Application Ref:	3/2025/0724			 Ribble Valley Borough Council www.ribblevalley.gov.uk				
Date Inspected:	3/10/25	Site Notice:	3/10/25					
Officer:	BT							
DELEGATED ITEM FILE REPORT:					APPROVAL

Development Description:	Erection of three-storey dwellinghouse with attached two-storey coach house adapted from existing structure. Planning permission previously granted (3/2024/0248) for similar sized house, existing house already demolished, and foundations for the accepted proposal have already been built.
Site Address/Location:	Hawthorn Bungalow, Rimington Lane, Rimington, BB7 4DP.

1 PROPOSED NORTH ELEVATION
1:100 @ A1 / 1:200 @ A3

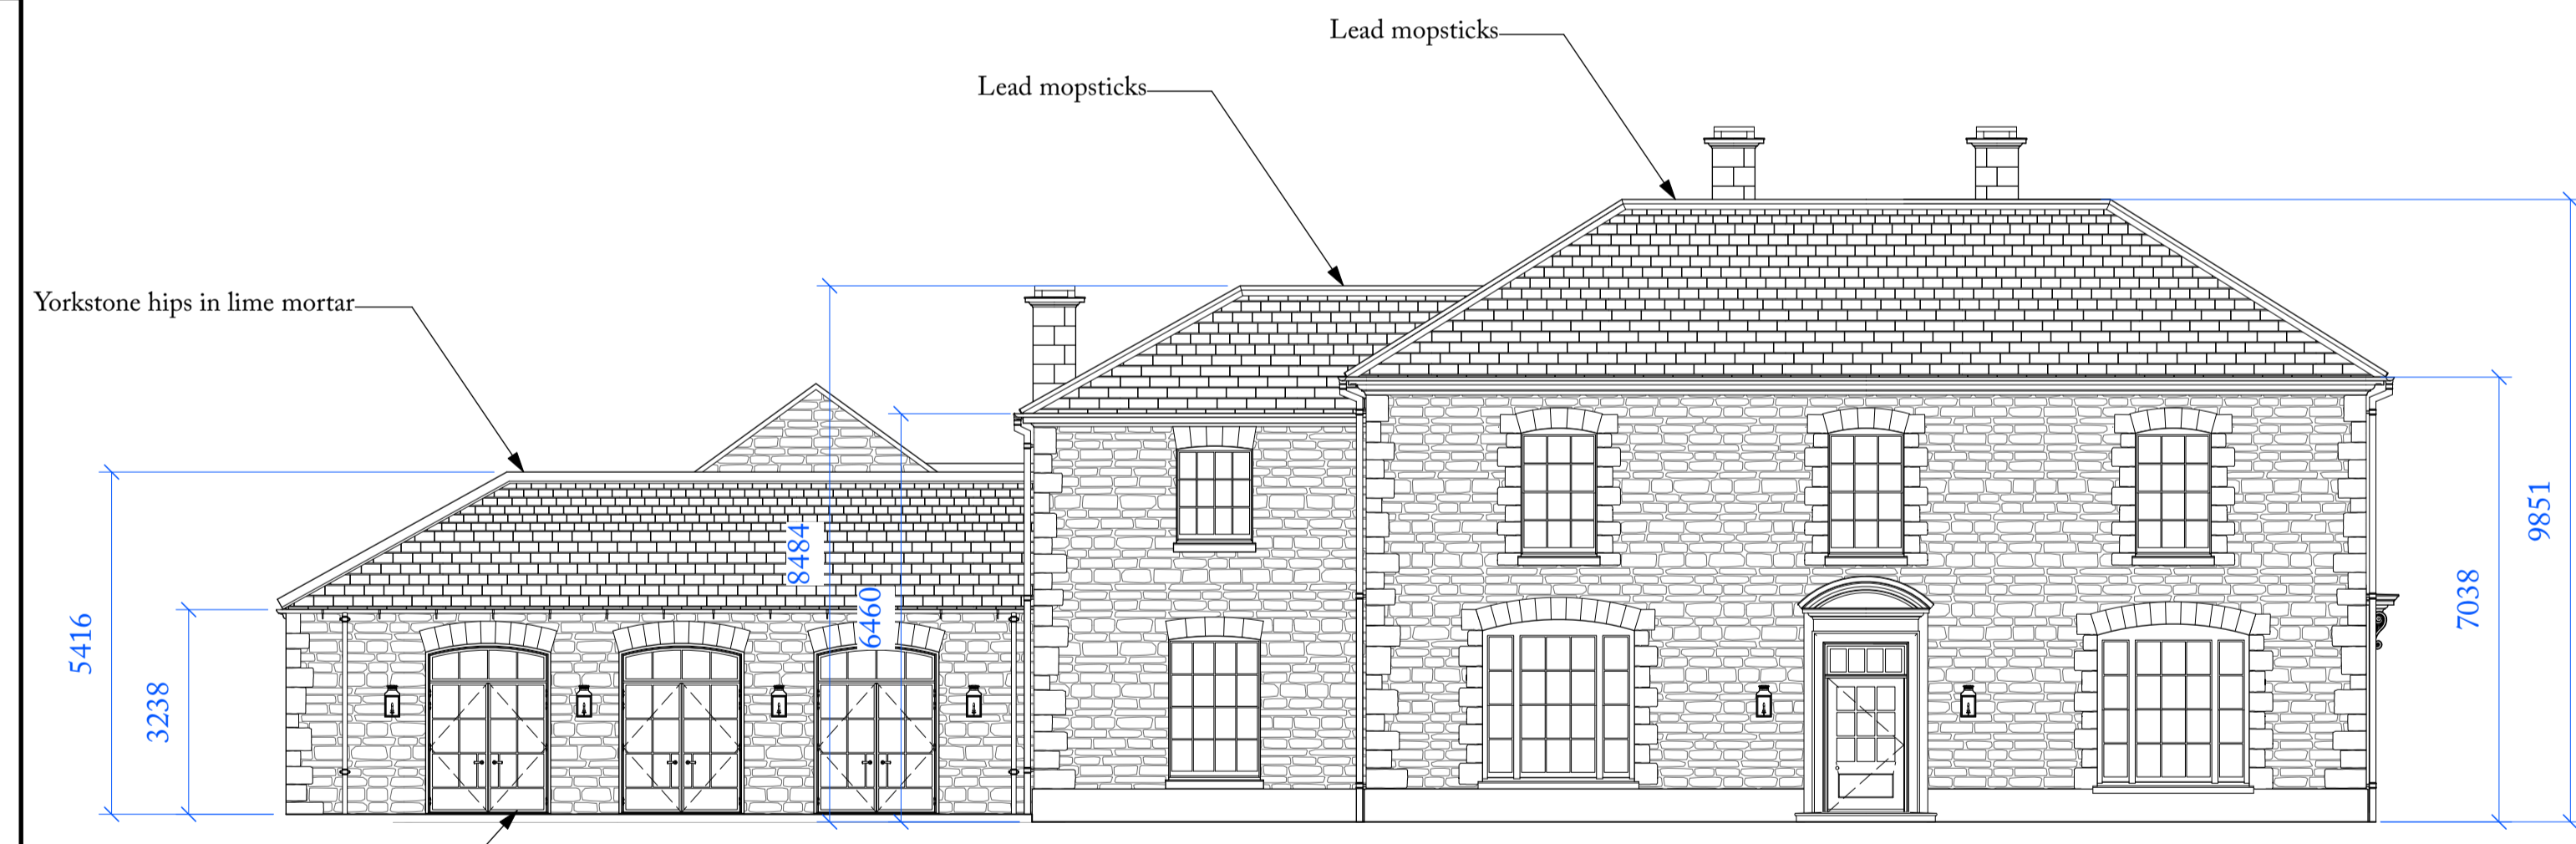
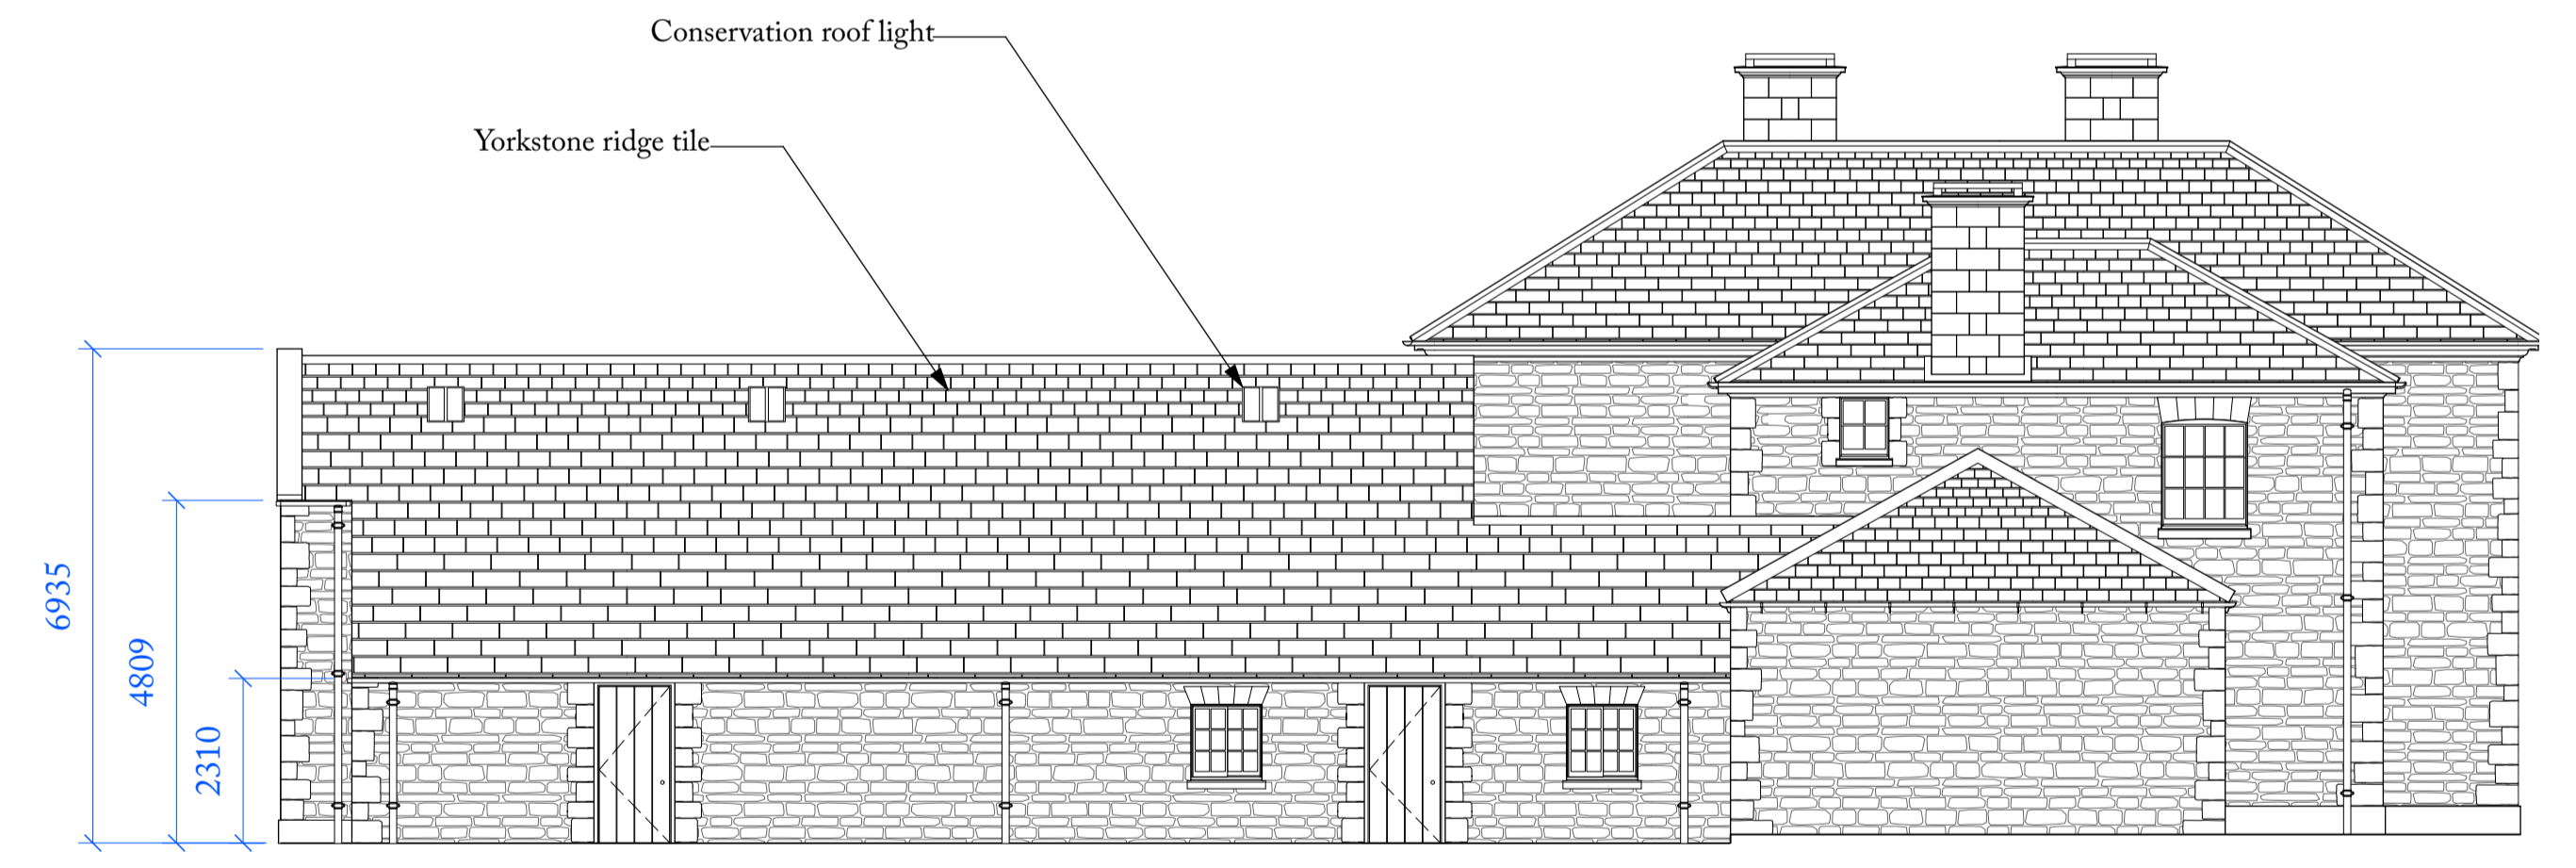
In this instance, the design of the proposed replacement dwelling as originally submitted comprised a sizeable two storey link element between the main house and its kitchen / living / dining room and boot room components. A sizeable integral garage component was also proposed initially with the Eastern facing eaves height of this structure comprising a height of just under 5 metres. These features were considered to be over dominant and unsympathetic additions to the main dwellinghouse by virtue of their bulk, massing and height, both of which were noticeably larger than the link and garage elements approved under previous application 3/2023/0660. In addition, numerous dormer and chimney features were proposed initially which were also considered to be unacceptable additions on the basis that these features would further exacerbate the bulk and massing effect of the proposed development. Further concerns were also raised with regards to the original sequence of fenestration proposed for the Southern and Eastern elevations of the dwellinghouse with respect to window quantities and proportions.

Following extensive negotiation an amended proposal has since been submitted with the principal elevation of the proposed link extension stepped back from the principal elevation of the main dwellinghouse and with

the floorspace within the upper level of the dwelling's integral garage component reduced, with these changes having subsequently created a clear visual break between the dwelling's link and garage components. Dormer windows have also been added to the upper level of the dwelling's integral garage component which in turn have facilitated a reduction to both the eaves and ridge height level of this structure. The dormer features previously proposed for the Southern and Eastern roof slopes of the dwelling have also been omitted from the proposal. These changes have resulted in a noticeable reduction to the bulk and massing effect of the proposal and as such are considered to be acceptable. In addition, reductions have been made to the width and height of the window openings proposed for the dwelling's Eastern elevation with a simplified design also incorporated to the architraves and door surround within this elevation. Furthermore, the proportions of the ground floor tripartite window openings within the Southern elevation of the dwelling have also been reduced. These changes have resulted in a more balanced sequence of fenestration and are therefore considered to be acceptable. The proposal seeks to retain five chimney features within the roofspace of the dwelling (omitting only one from the original scheme) however on balance the chimney features are not considered to be excessive in terms of size and would be evenly distributed across the roofspace of the dwelling. As such, the retention of these features within the proposed development is considered to be acceptable.
